Our Ref: P/127/25/DOC

**Approval of details reserved by condition imposed under P/25/17/OUT relating to conditions 4-
Construction Phasing Scheme, 5-Materials Schedule, 9-Arboreal Method Statement, 15-
Ecological Management and Mitigation Plan, 20-Employment and Skills Plan, 22-Renewable Energy,
23-Broadband Provision and 26-Electrical Vehicle Charging.**

Church Barton House Horns Lane Pagham PO21 4NZ

Arun District Council have decided to **REFUSE details reserved by condition for the following reasons:**

Project	NEW DWELLINGS AT LAND SOUTH OF SUMMER LANE FAGHAM PO21 4NJ		Drawing	STATEMENT OF DETAIL - SHEET 2	
Client	HAMPSHIRE HOMES		Job-Dwg Number	22039-SOD-02	Rev. -
Status	PLANNING		Scale	1:50 (1:100 @ A3)	Sheet Size A1
Author	JH	Checked RR	Date	SEP 2025

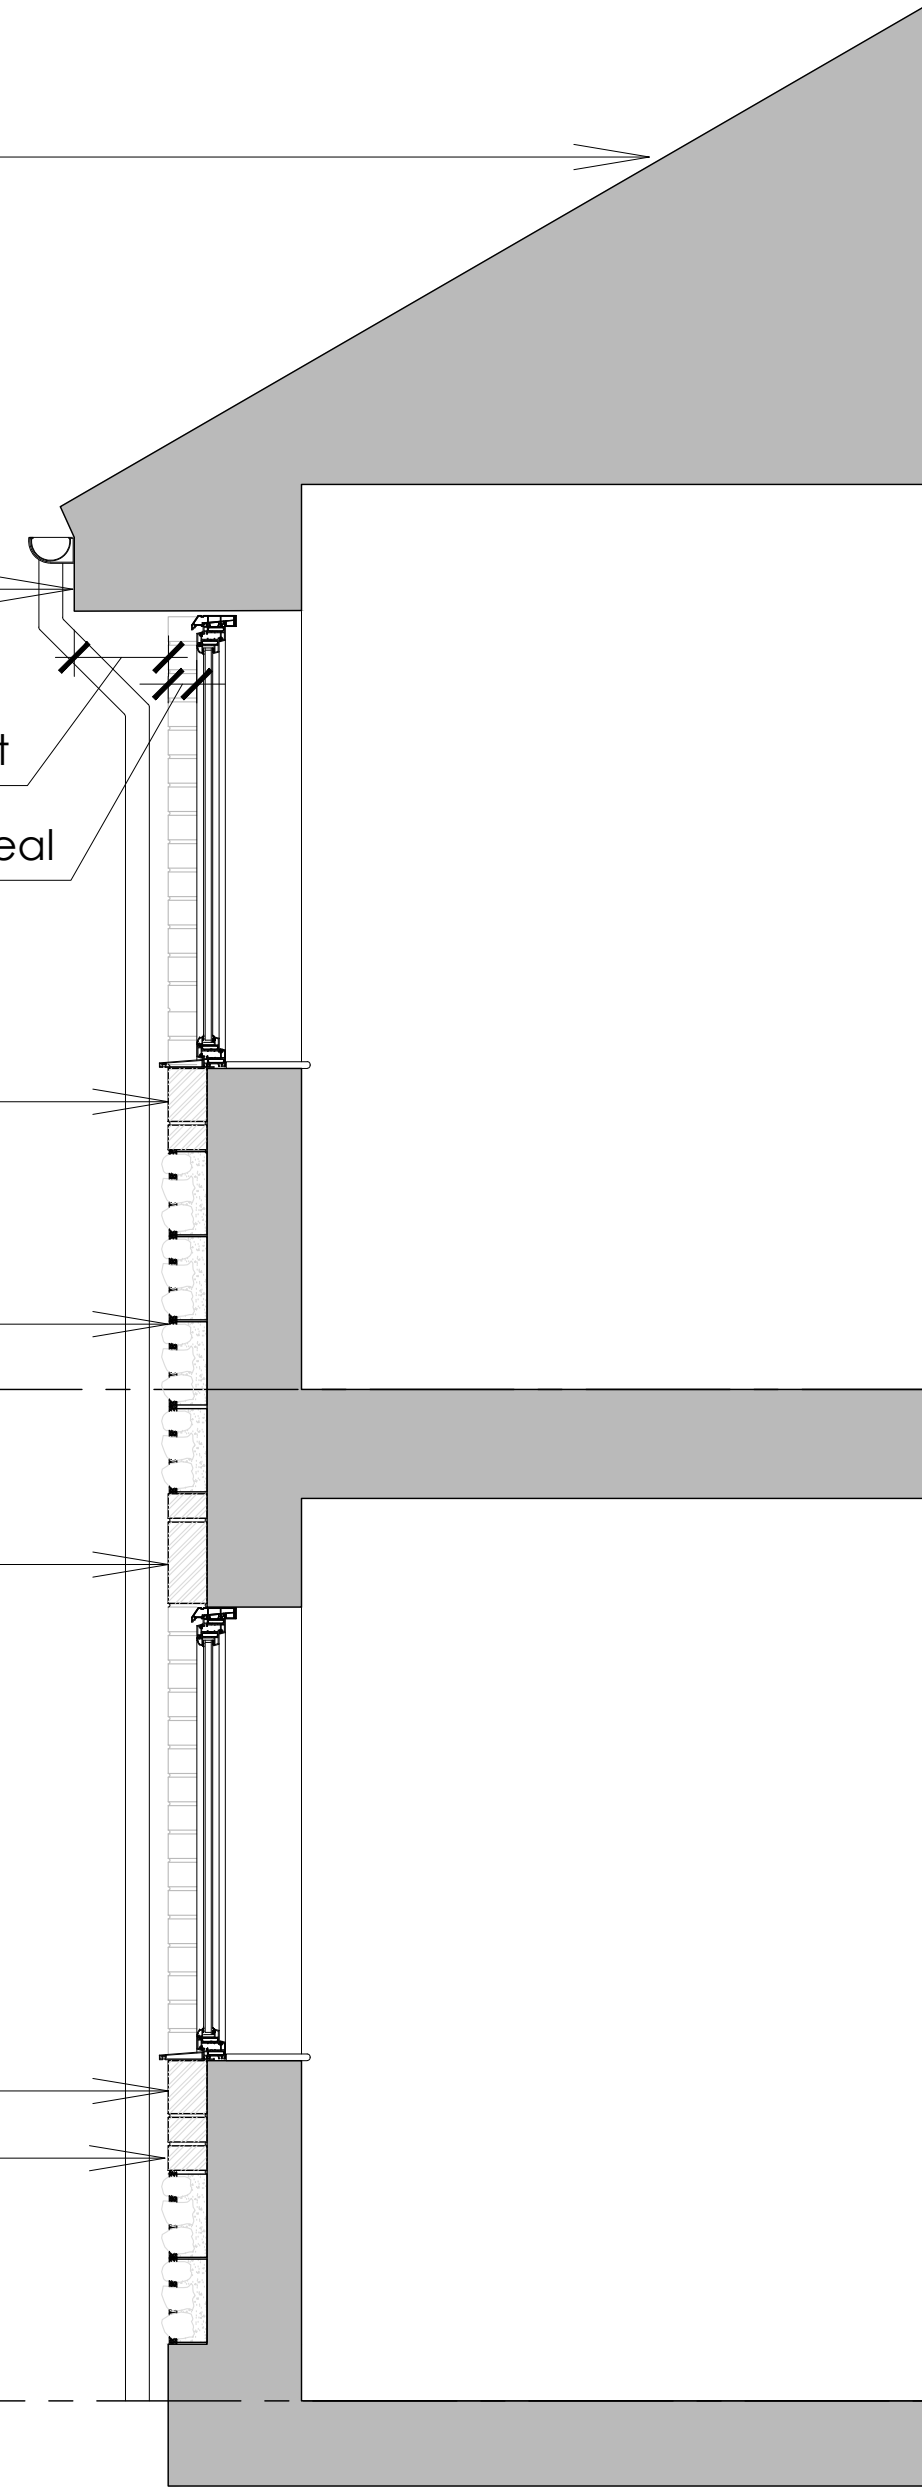
- Flint specification
- Specification of the brick type that will be used for brick detailing
- Specification of the brick type used for brick Quoining
- Specification of brick work for the lintels
- Rainwater goods details (colour and material)
- Door and window details
